Road Safety Audit Report

Stage 1a Completion of Initial Preliminary Design.

**Proposed Access off the
A259 New Road, Rustlington**

Job no	RSA-15-002	Issue no	6	Date	September 2015
Prepared by	JJF	Verified by	AJB	Approved by	JJF
Filename and Path	Fenley/Road Safety Audits/RSA-15-002-06

Title
HIGHWAY ACCESS PLAN

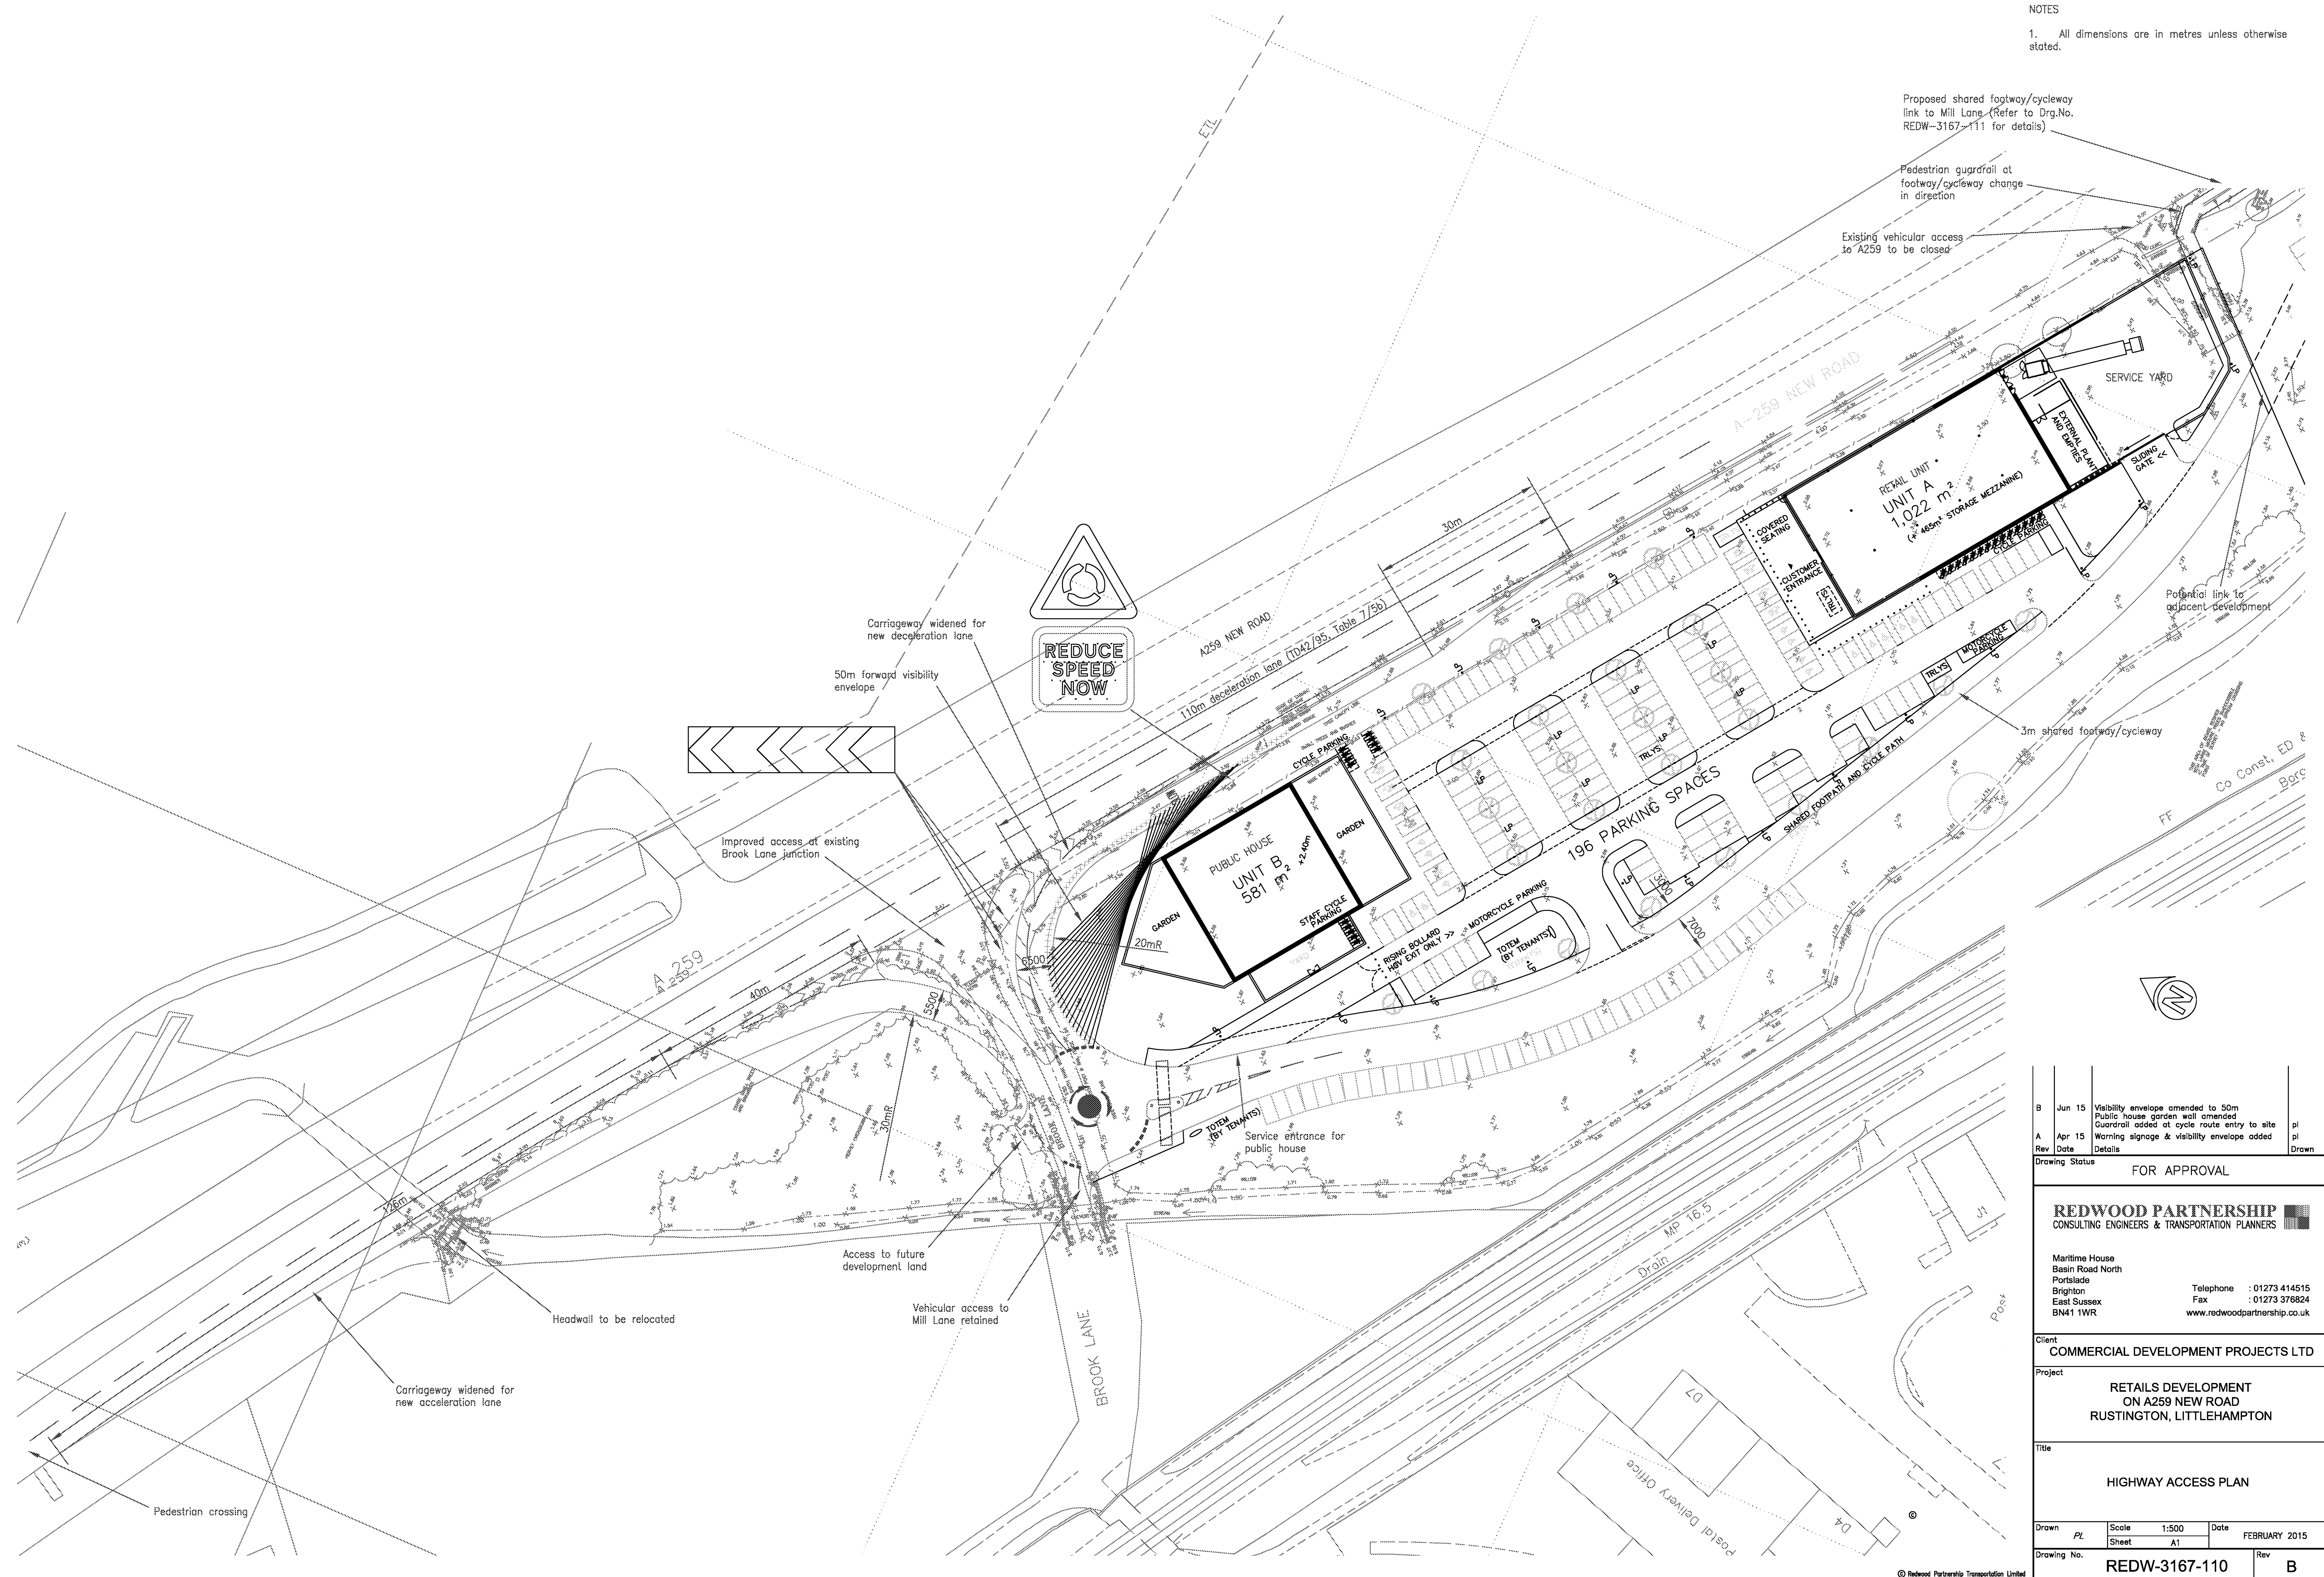
A.a.2	LOCAL ALIGNMENT	
A.a.2.1	PROBLEM Tight entry corner radius Accident Type <i>Loss of Control</i> Location Entry radius from deceleration lane <i>The proposed deceleration lane is provided for vehicles to decelerate from the derestricted A259. Vehicles could therefore be travelling in excess of the speed required to safely manoeuvre around the 20 metre corner radius. This could result in vehicles losing control and striking the island.</i> The appropriate chevron and warning signs should be installed in clear view of vehicles utilising the deceleration lane to ensure that drivers are aware of the corner. 	Chevron sharp deviation of route signs (Diag. 515) have been included on the central approach island as shown on Drg.No. REDW-3167-110-Rev A

Audit Item No.	Audit Team Observation	Audit Team Recommendation	Designer / Scheme Response
A.a.2.2	PROBLEM Restricted visibility around the exit corner radius Accident Type <i>Shunt</i> Location <i>Inside of exit radius to the acceleration lane</i> <i>Forward visibility vehicles accelerating from the roundabout to the acceleration lane to vehicles utilising the acceleration lane, is restricted by vegetation. Therefore drivers will not have a clear view of preceding vehicles. This could result in shunt type accidents should a driver hesitate and stop along the acceleration lane.</i>	Vegetation should be cleared to the appropriate level to allow for the clear forward visibility.	Vegetation will be cleared to a distance of 3m from the kerb line of the site at the radius of the site egress. The verge area adjacent to the carriageway will be offered for adoption as Public Highway

Audit Item No.	Audit Team Observation	Audit Team Recommendation	Designer / Scheme Response
A.3	JUNCTIONS		
A.a.3.1	PROBLEM Forward visibility to the roundabout is restricted Accident Type <i>Shunt type accidents</i> Location Roundabout Forward visibility to the give-way road marking at the roundabout from the deceleration lane is restricted to approximately 50 metres based on the building line of the adjacent pub/restaurant. This could be further restricted should a fence be erected around the associated grounds and could result in shunt type accidents where vehicles are stopped at the give-way.	Warning signs should be installed to ensure that approaching vehicles are aware of the presence of the roundabout and the pub/restaurant should be restricted from erecting a fence where it blocks forward visibility. 	Forward visibility to the site roundabout is restricted due to a boundary wall proposed around the public house garden area. The achievable forward visibility envelope is shown on Drg.No. REDW-REDW-3167-110-Rev A. An advanced warning sign of roundabout ahead (Diag. 510) and REDUCE SPEED NOW supplementary sign (Diag. 511) and SLOW road marking is proposed in advance of the roundabout which will mitigate the reduced forward visibility to the roundabout give way.

PROPOSED OFF-SITE FOOTPATH/CYCLEPATH LINK

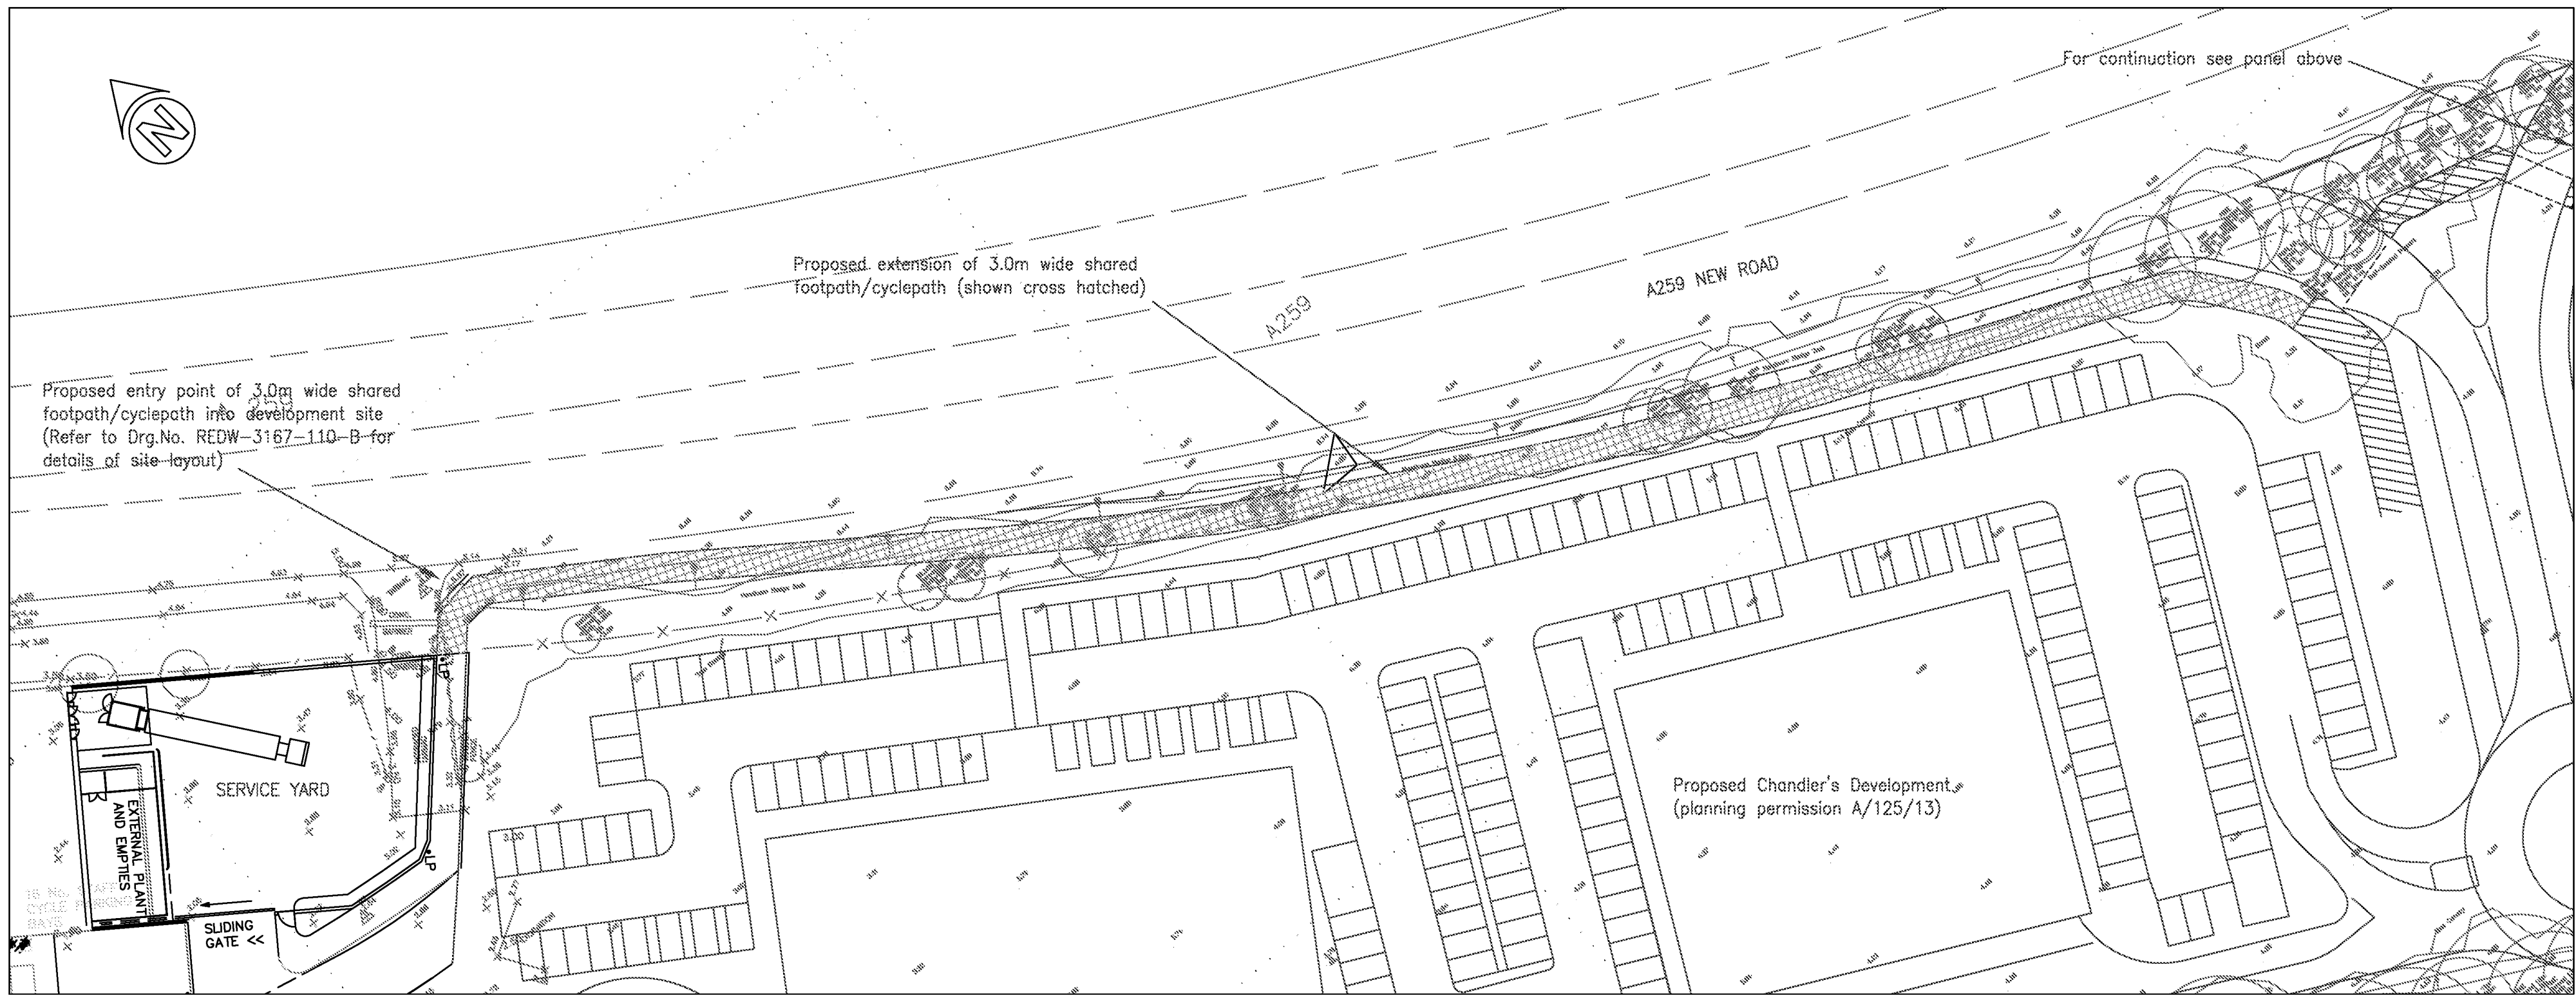
Audit Item No.	Audit Team Observation	Audit Team Recommendation	Designer / Scheme Response
A.a.4.2	PROBLEM Footway / Cycleway link guides into A259 carriageway Accident Type <i>Vehicle/Pedestrian, Cyclist Collisions</i> Location East of service yard The footpath/cyclepath link that is proposed, heads in a northerly direction adjacent to a service yard and bends 90° to a facility that is to run alongside the A259 carriageway. The 90° bend could result in cyclists losing control and pedestrians travelling into the path of vehicles on the A259. 	A section of guard railing should be introduced to ensure that non-motorised users follow the line of the footway/cycleway and do not enter the A259 carriageway.	A section of guardrail will be included at the detailed design stage. The guardrail will prevent non-motorised users from entering the A259 carriageway.
A.a.5	ROAD SIGNS, CARRIAGEWAY MARKINGS, LIGHTING AND DRAINAGE
